**From:** [Joerg Arnhold](#)  
**Sent:** Wednesday, August 17, 2016 7:38 PM  
**Subject:** P/76/16/PL Barfoot's Sefter Farm

Re. Planning Application for Barfoot's of Botley, Sefter Farm P/76/16/PL

client			
BARFOOTS OF BOTLEY			
project			
Proposed Production Facility			
Setter Farm			
Pagham			
title			
Proposed Elevations			
date	scale @ A1	drawn	chkd
May 2016	1:200@A1	KJB	GBC
project no.	drawing no.	rev	
1603	P107	05

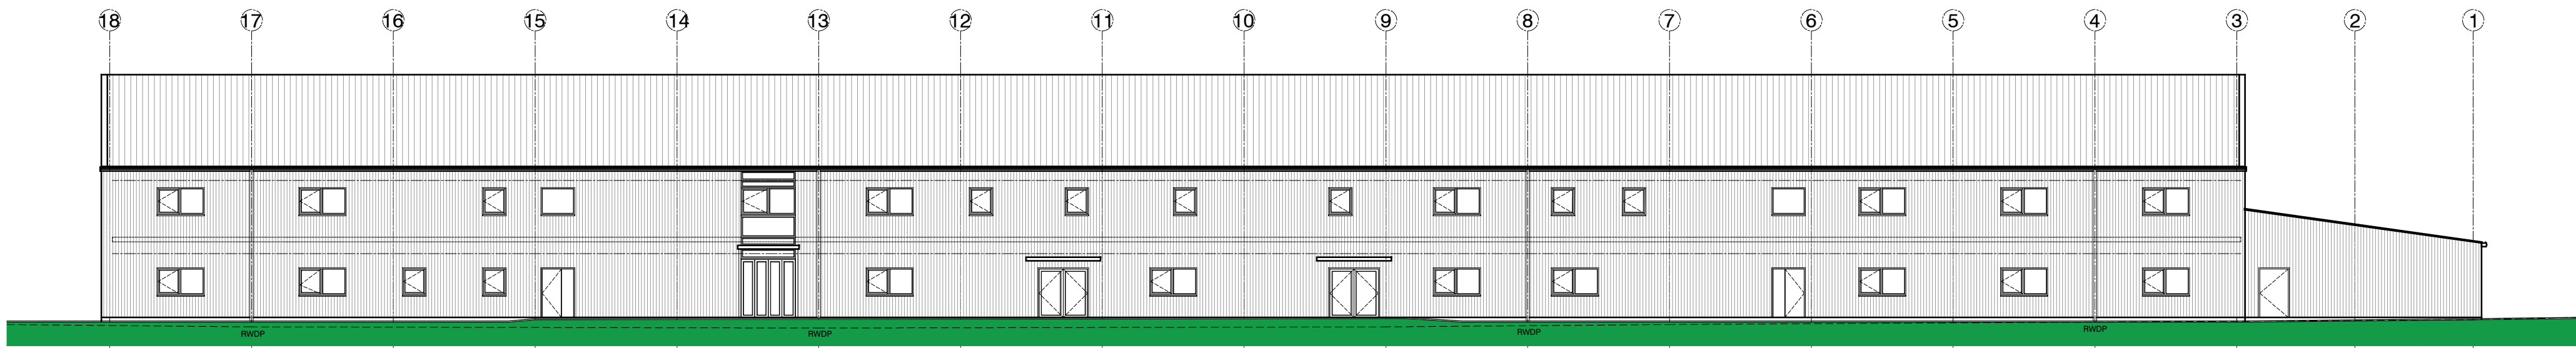
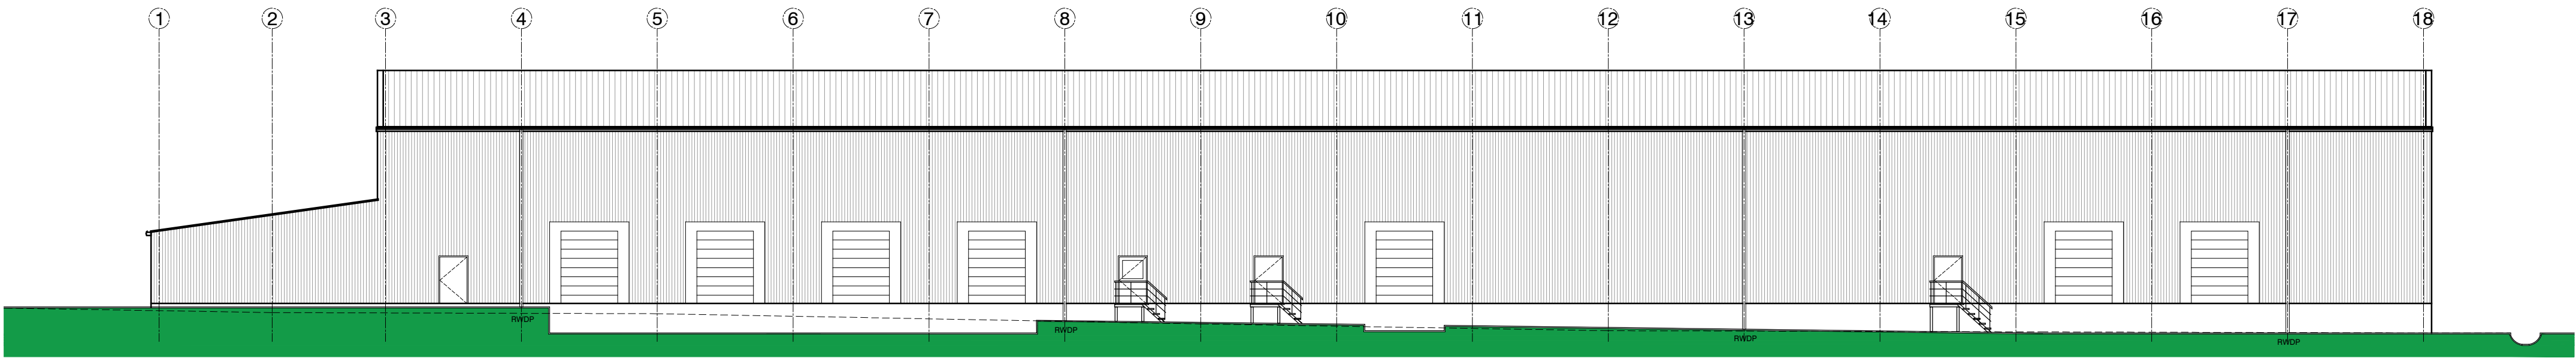
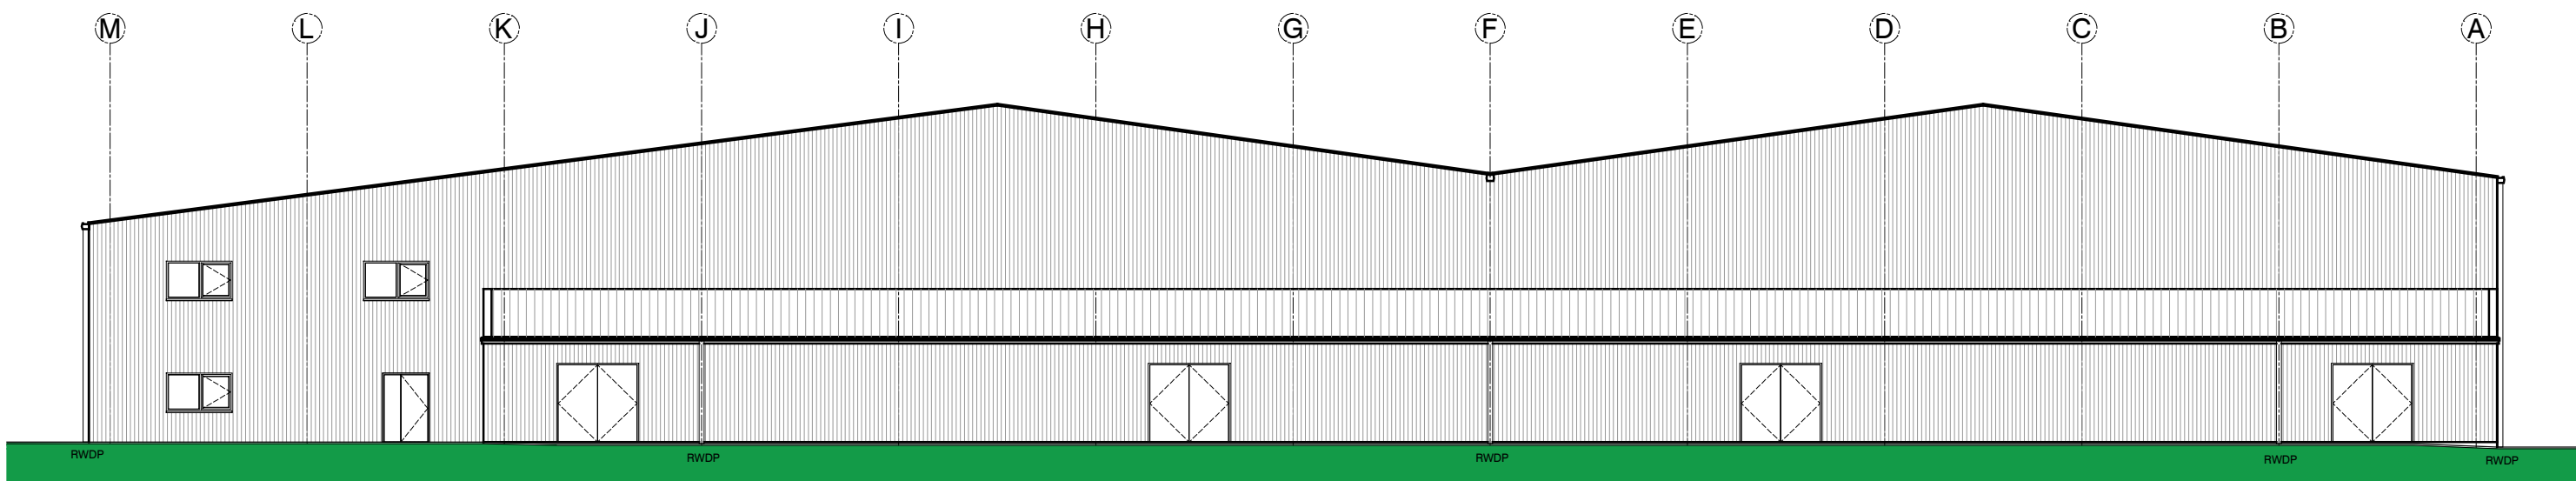
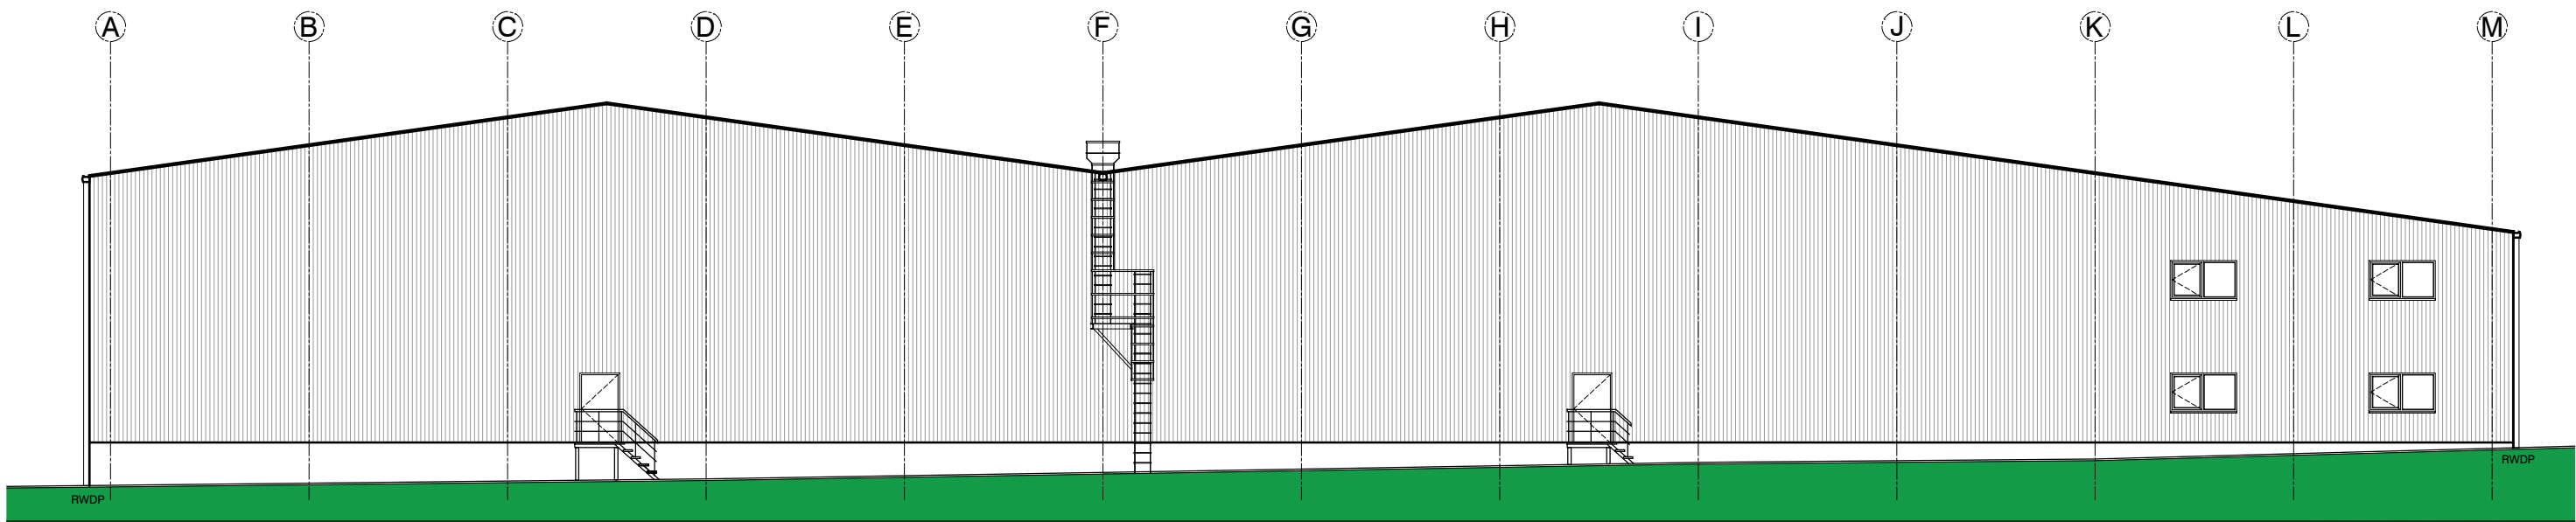
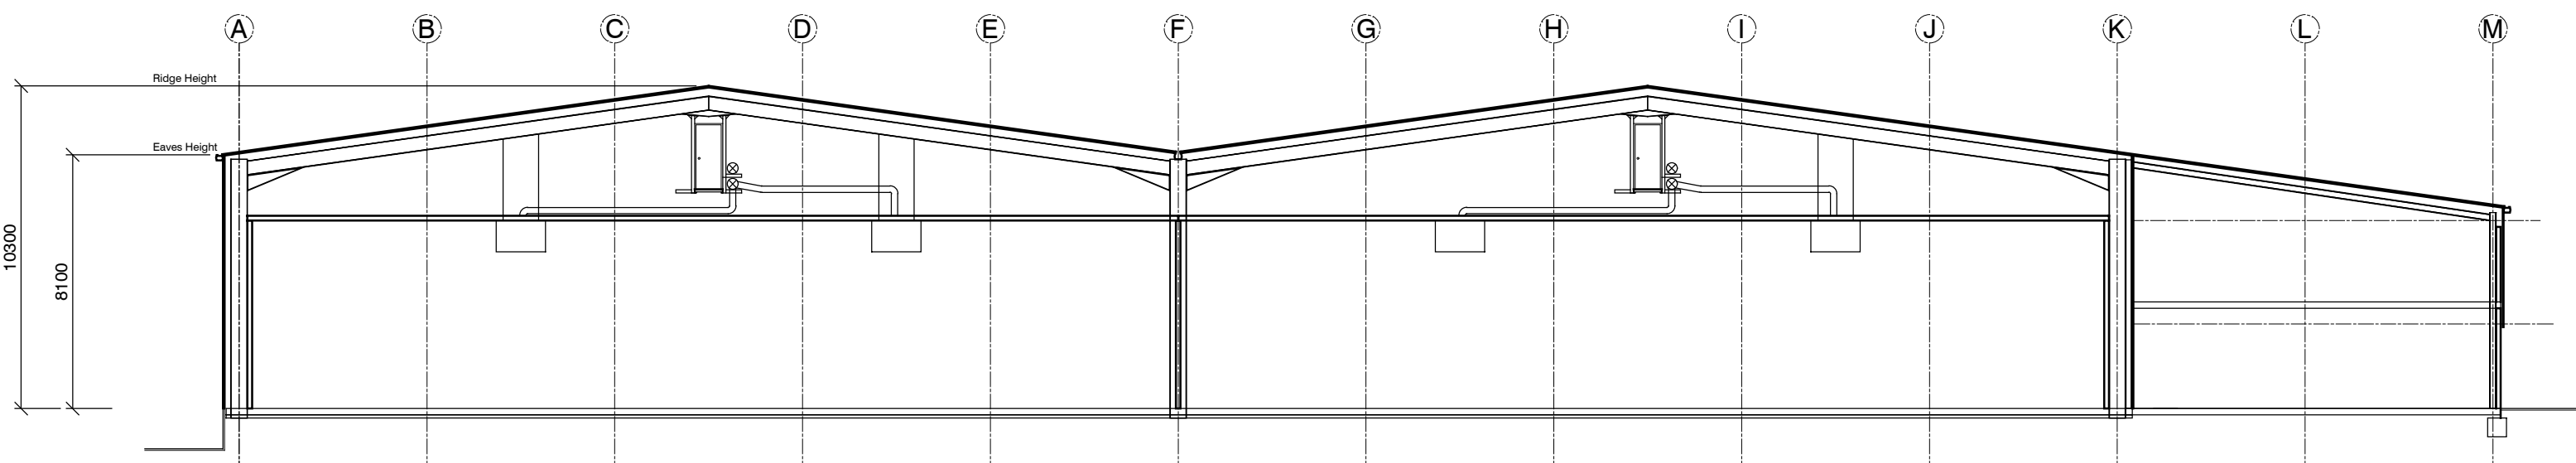
The packhouse plans show the south elevation raised by ca. 1.0 metre which in effect raises the roofline to 11.00 metres.
